1919 MAIN STREET, LLC
1919 MAIN STREET
PARCEL NO: 65020-00-028
ZONE: CC CAD-O
USE: SERVICE GARAGE

① SITE PLAN (CONCEPT)

SMITH PLUMBING & HTG
1875 MAIN STREET
COLORADO SPRINGS, CO 80911
EL PASO COUNTY, COLORADO

1 SITE PLAN (CONCEPT)
SCALE: 1"=30'-0"

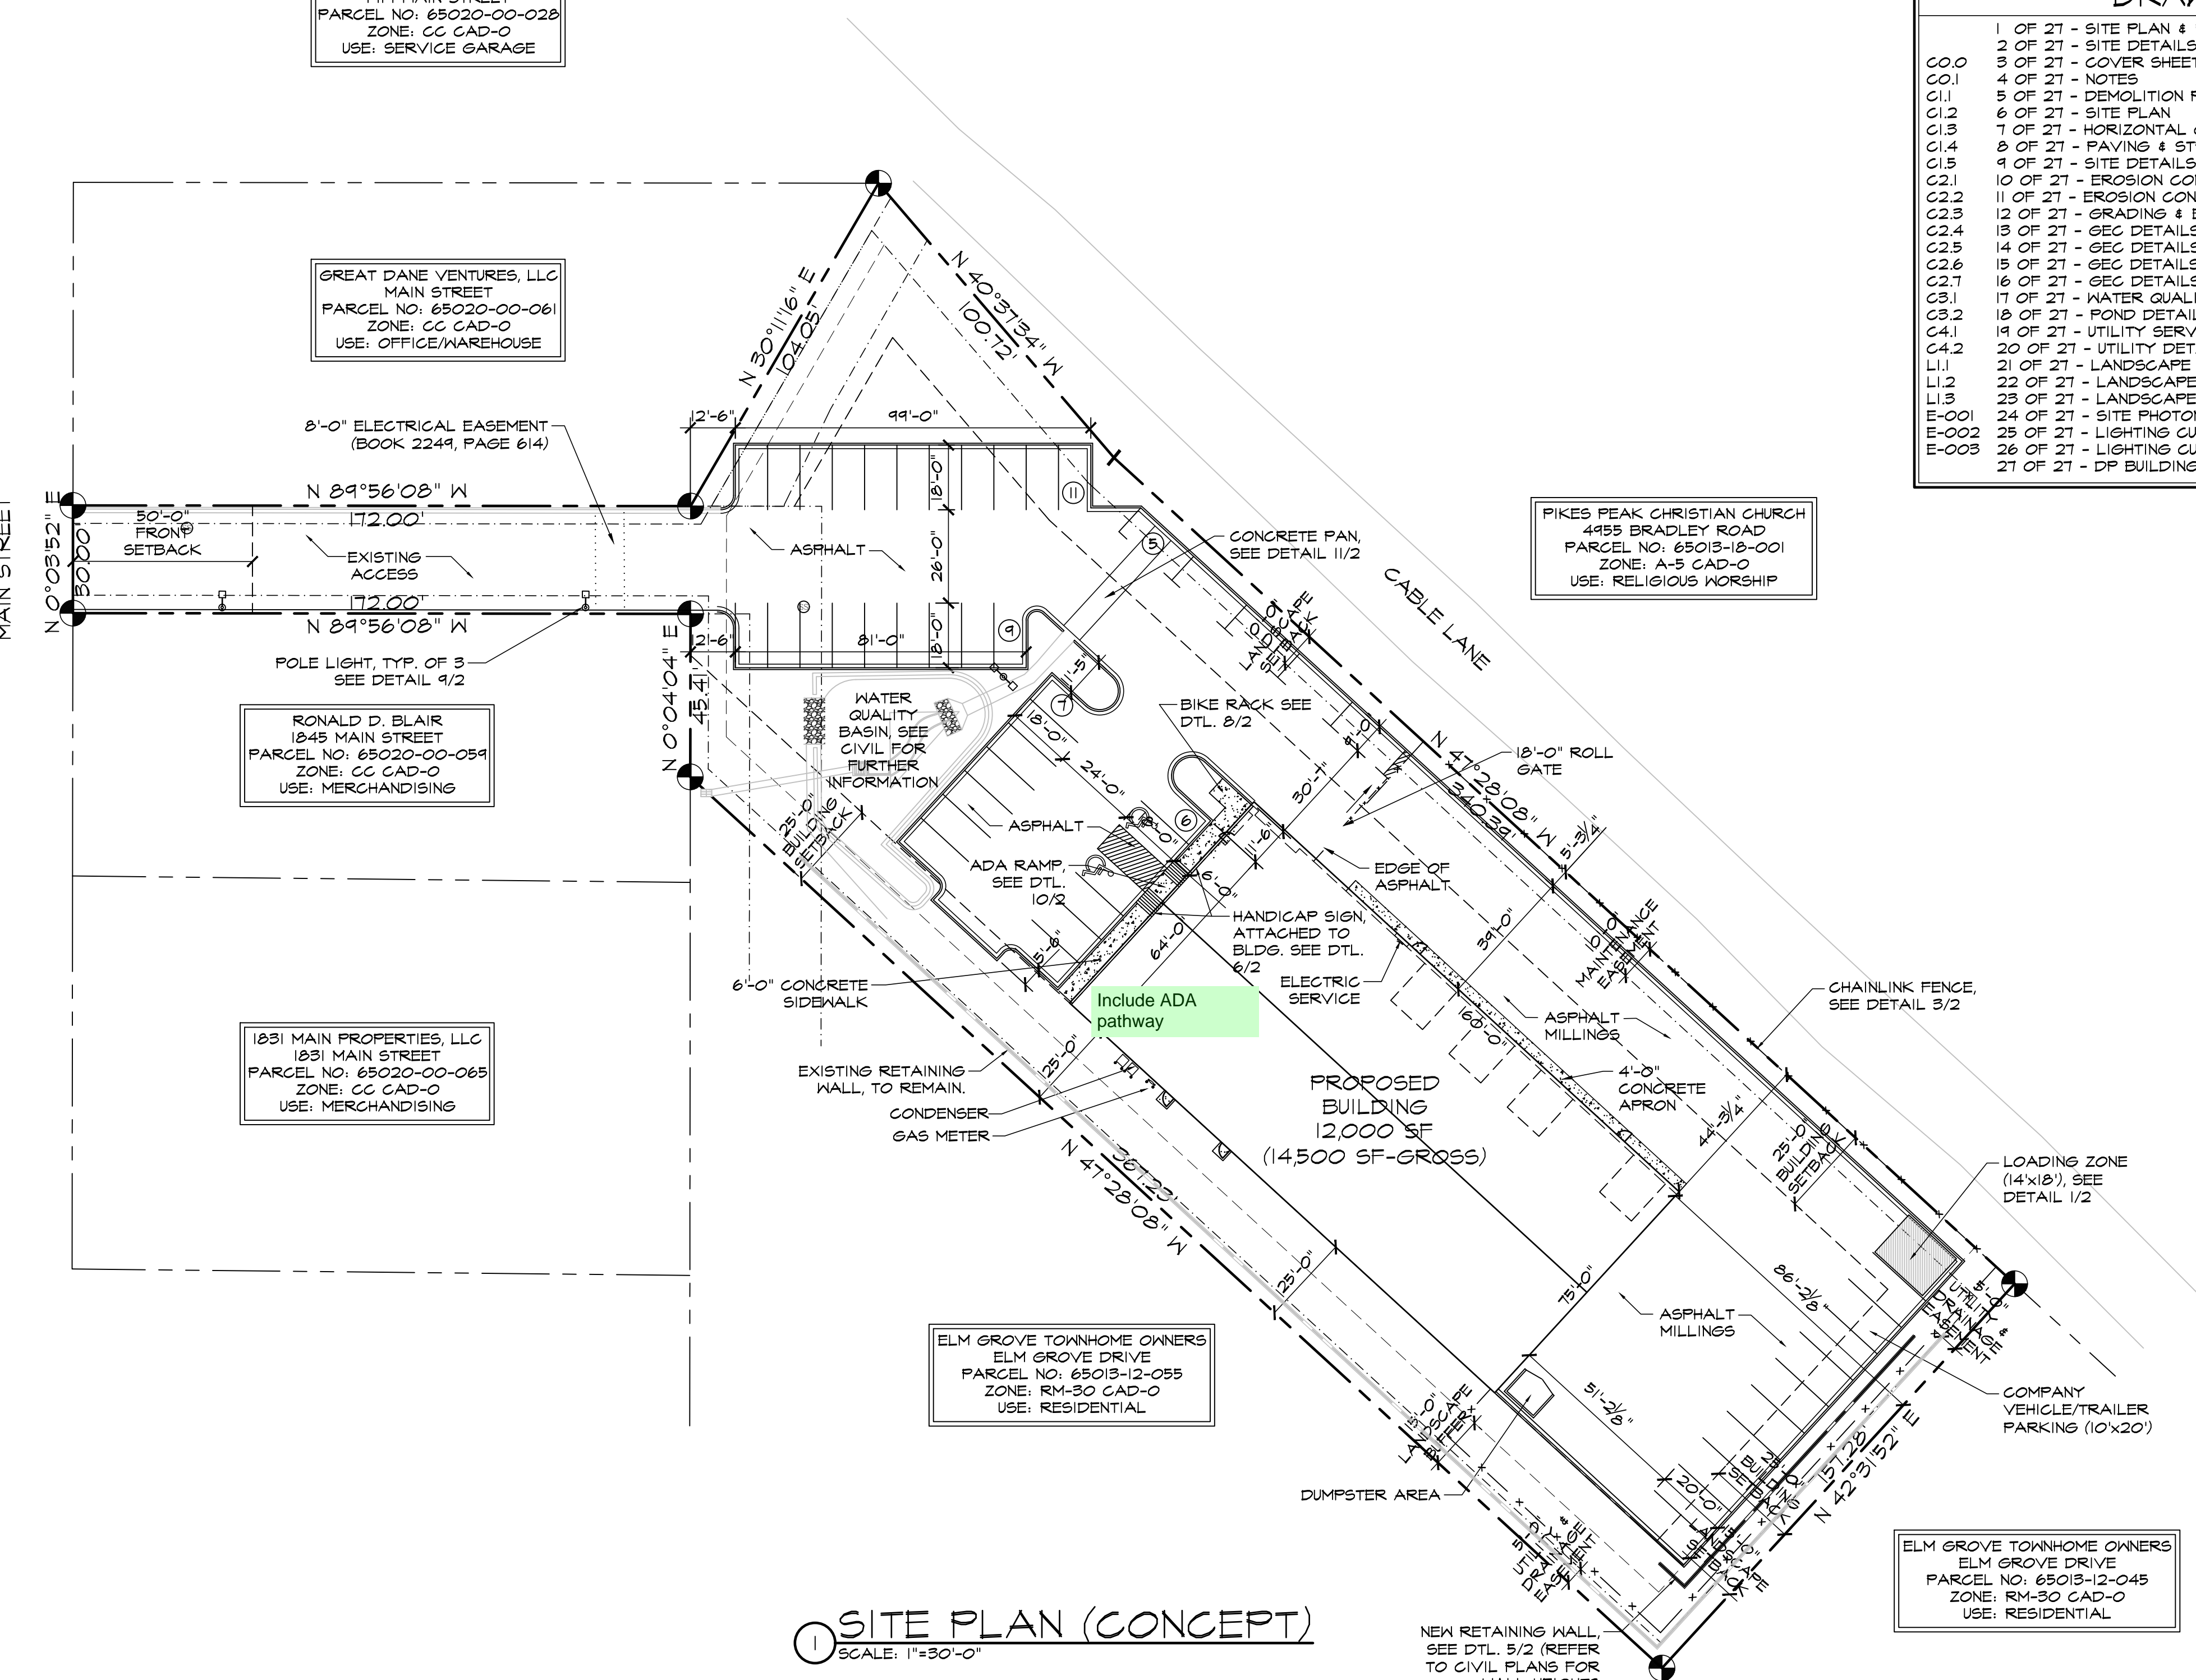
*Please show and label all the existing utility easements, and provide reception number or book, and page numbers.

*Please show the proposed gas and electric meter locations.

*Please show the proposed transformer location.

It appears that the proposed water
quality basin is shown in the existing
utilities easement. Water quality
basins (including any retaining walls)
are not allowed in any public utilities
easements.

GALLOWAY - Basin limits
revised to remain outside
of the easement
